GOOLGOWI POULTRY COMPLEX

375 MCRAES ROAD, CARRATHOOL

**RESPONSE TO AGENCY
AND
PUBLIC SUBMISSIONS SSD 8036**

December 2018

DETAIL A - LPG TANK COMPOUND SITING
(1:250 @ A3)

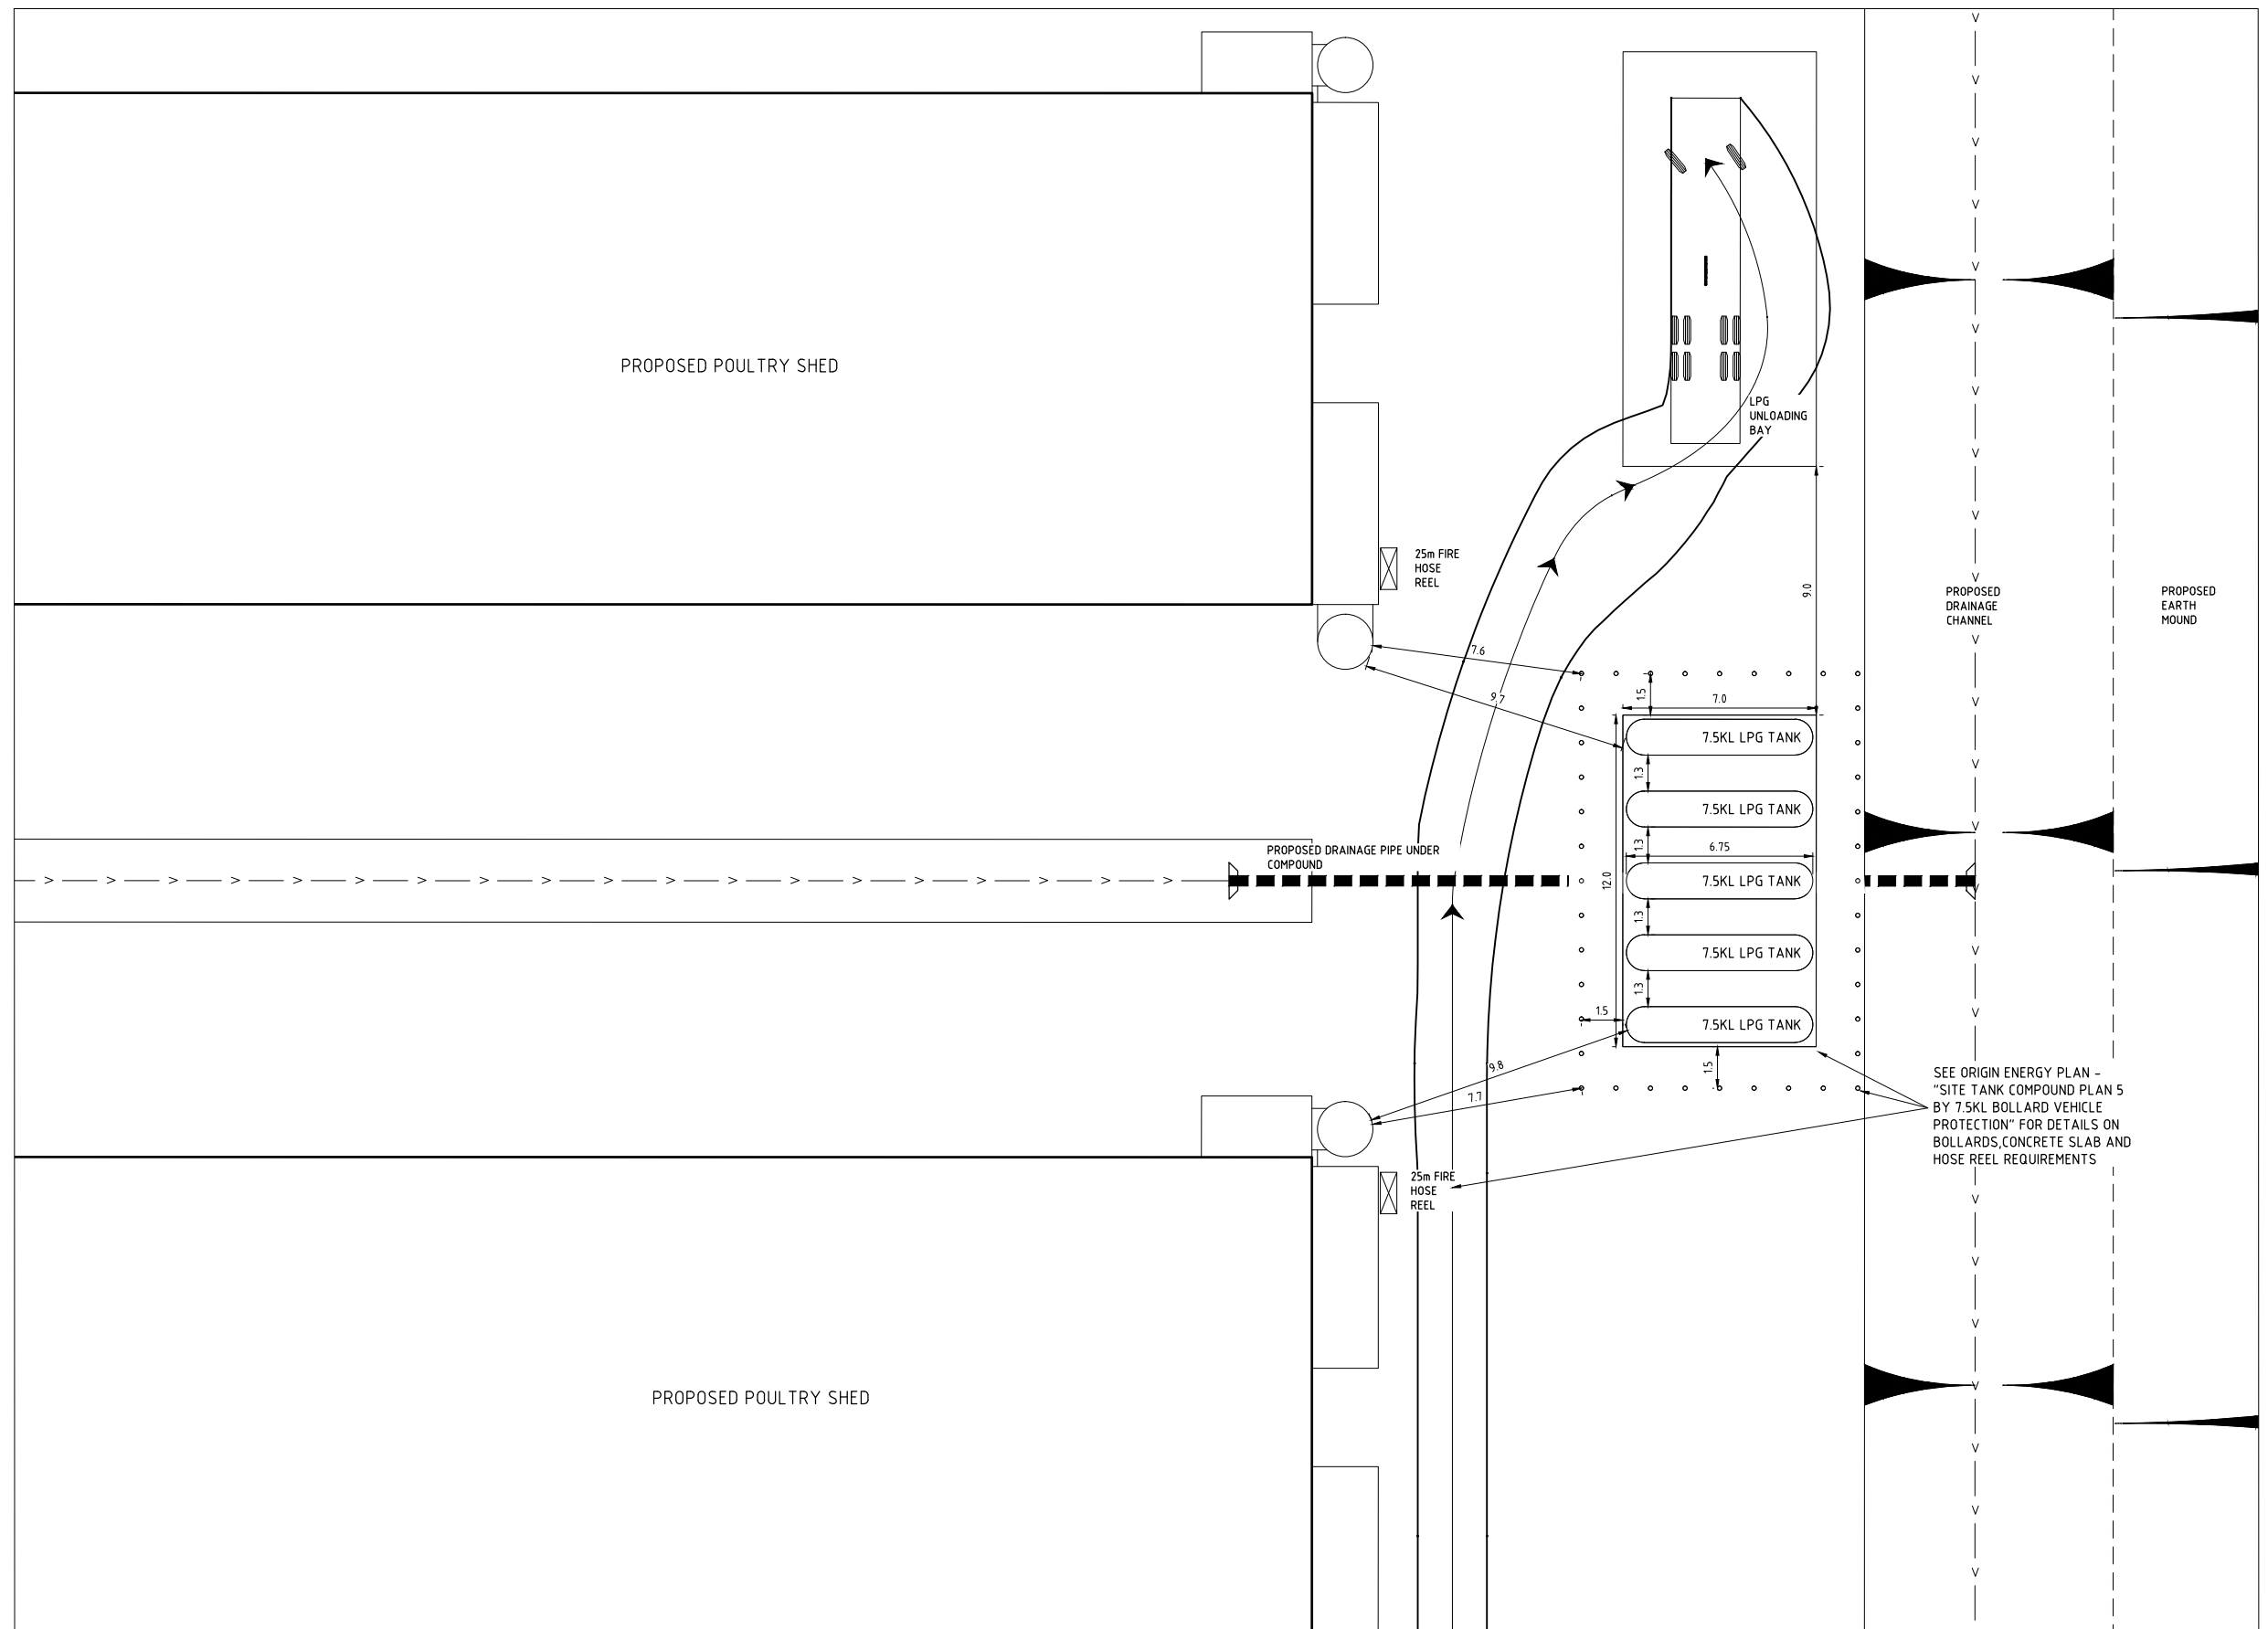
- Amended plans highlight the location and operational aspects of the gas tank arrays for each farm. The gas tank arrangements have been prepared utilising an Origin Energy (the preferred supplier of the tanks and gas supply) standard layout plan.

For each farm the gas tanks will be located in two (2) locations each location having 5 tanks. Each of the gas tank arrays will be the same for all farms and there will be no variations between the farms. A detailed plan indicates the location of the gas tanks and notes that AS 1596-2014 requires clearance of 9.5m from a tank to a public place and this is interpreted as being a poultry shed. A distance of at least 9.7m is available. Refilling distances required for the LPG Unloading Bay are required to be at a minimum of 6m from the tanks with 9.0m being made available.

The specifics of this arrangement are clearly indicating compliance with the Australian Standard and this level of compliance is further validated by the supplier and owner of the tanks being Origin Energy. No part of the installation of the gas tanks is at variation to the usual operational aspects of such an installation and the proposal is expected to be a normal operational issue for the supplier as well as the farm operator.

STANDARD SYMBOLS
EROSION AND SEDIMENT CONTROL PLANS

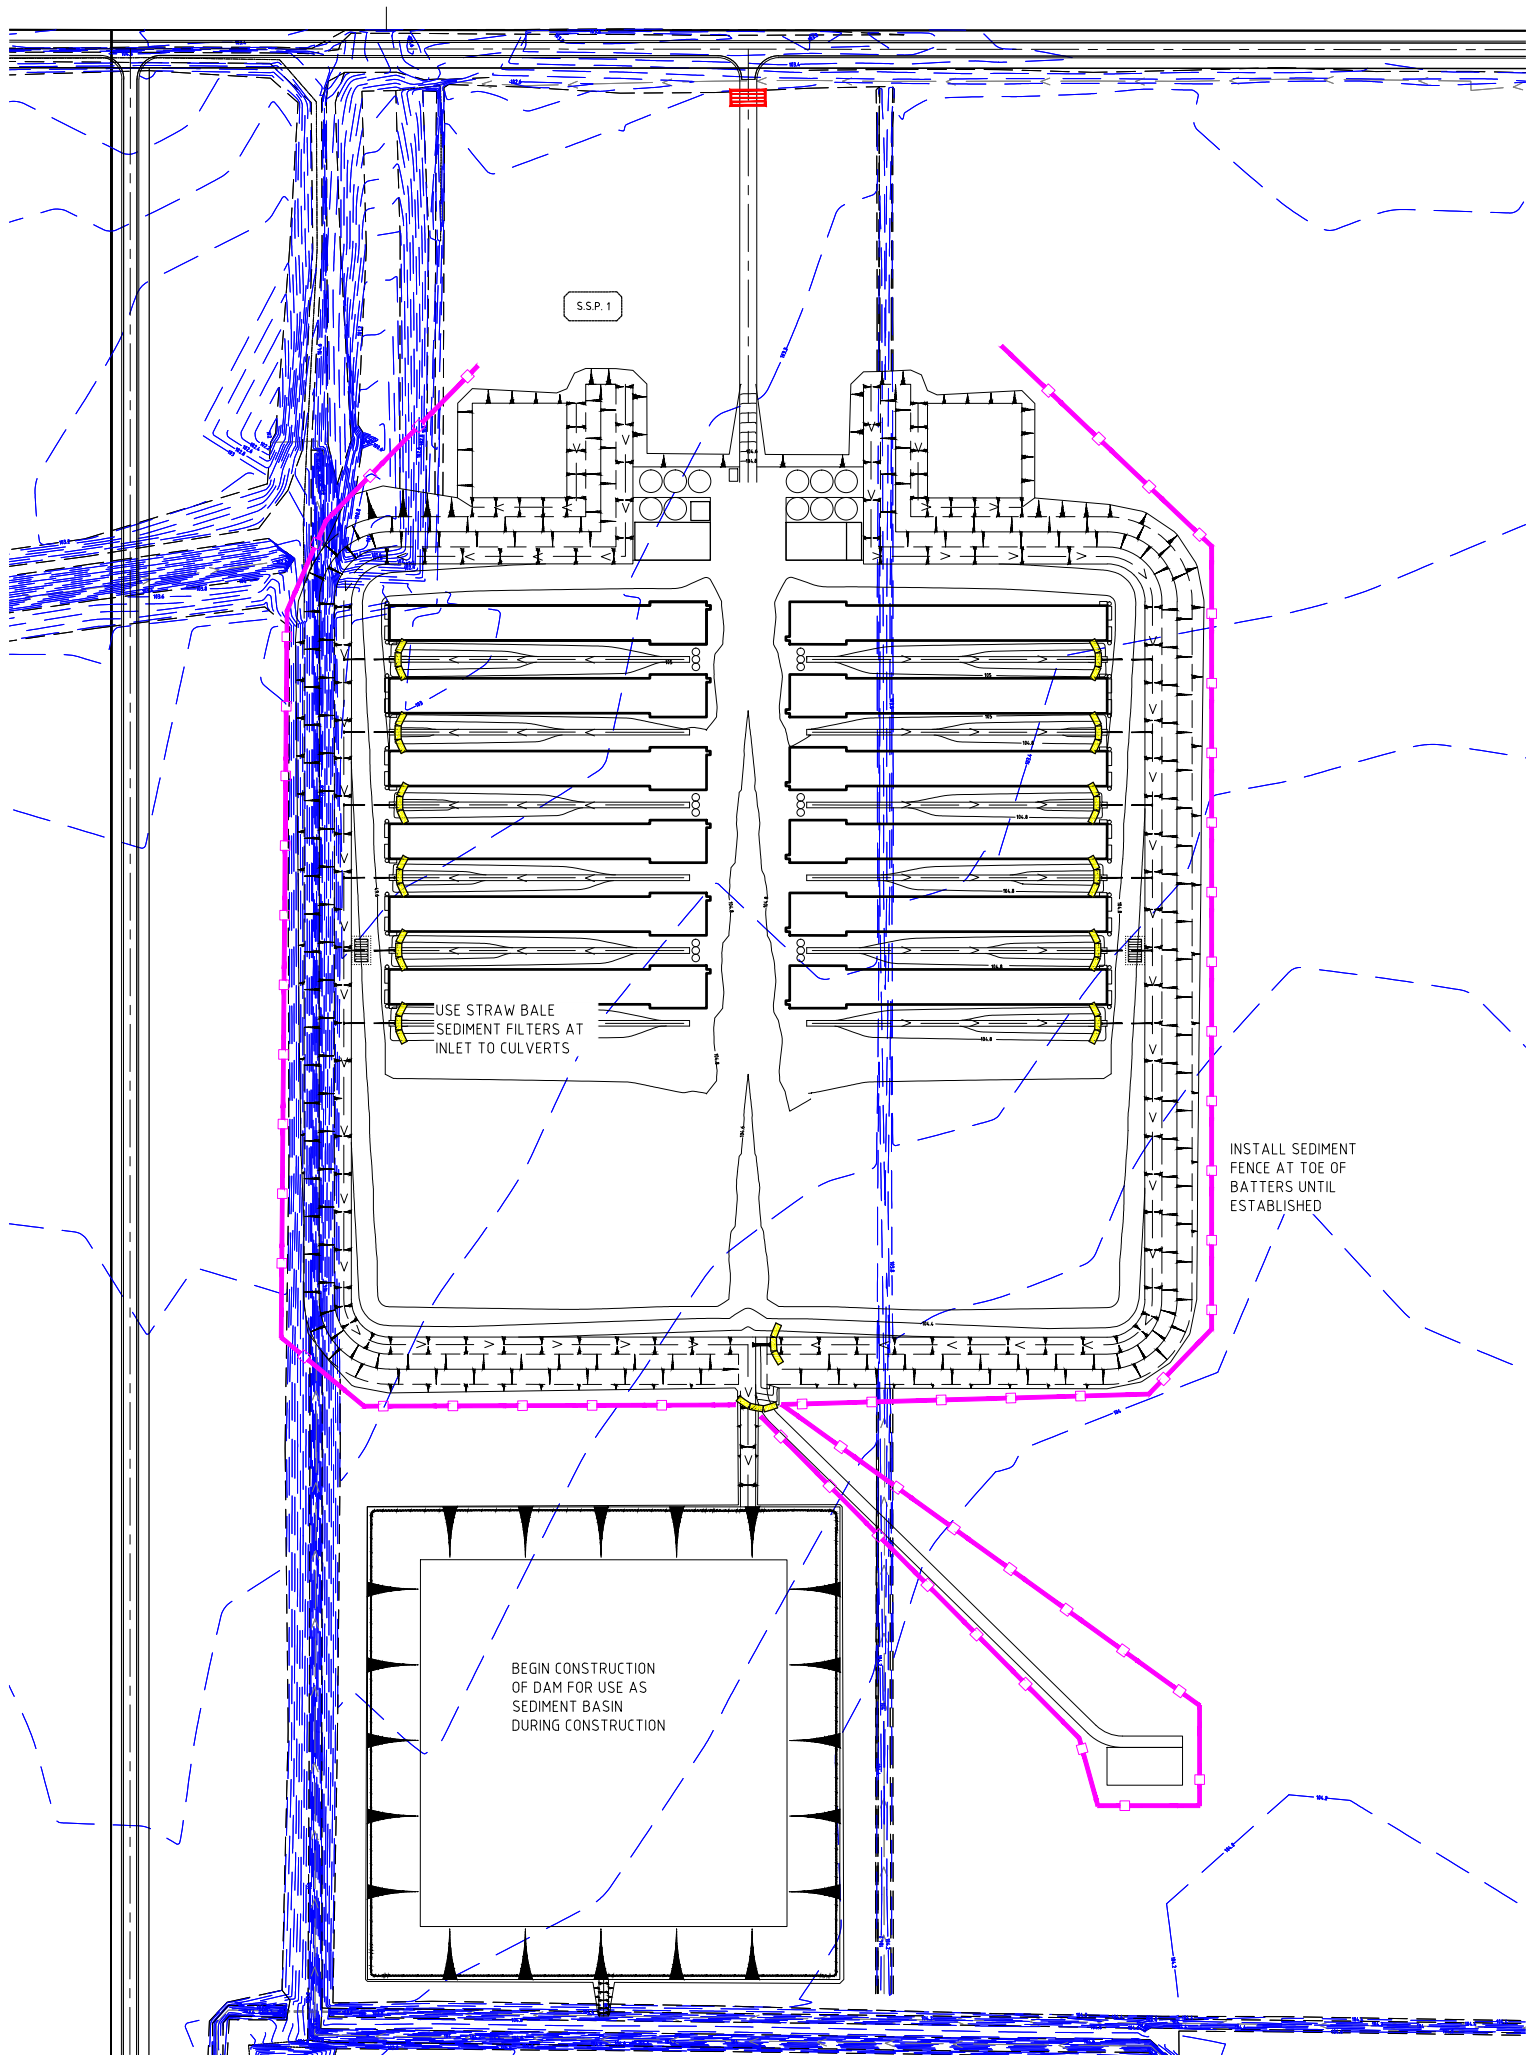
- b. Refer attached plan for the typical erosion and sediment controls and note that the main dam will be the source of all required fill and act as the construction sediment basin for the construction operations.
